From: Jeff Watson
Sent: Monday, February 25, 2013 9:13 AM
To: Holly Duncan
Subject: RE: BL-11-00024 Otte

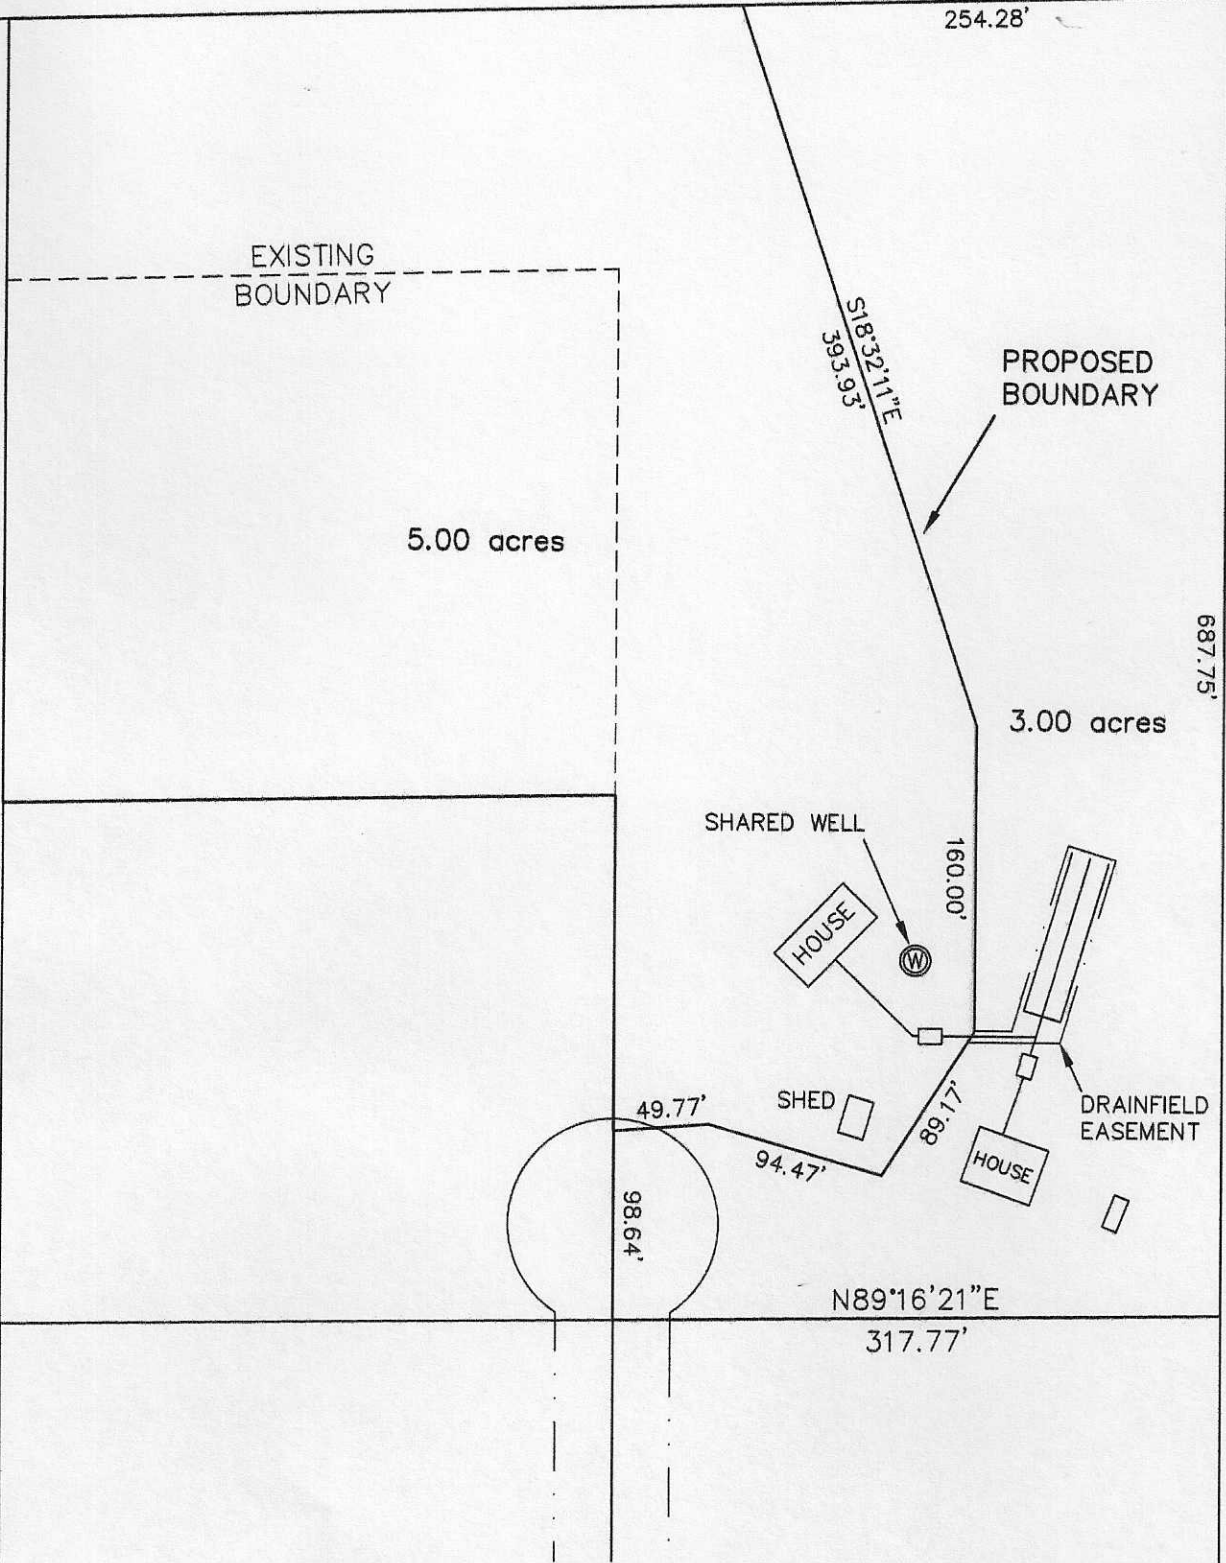
I also have questions on this one. It appears that the proposed project will have a lot line going through the area where the house, well site and drainfield might be. I need a better site plan showing the location of the well and on-site sewage system in relation to the proposed lot line. Can the applicant provide this?
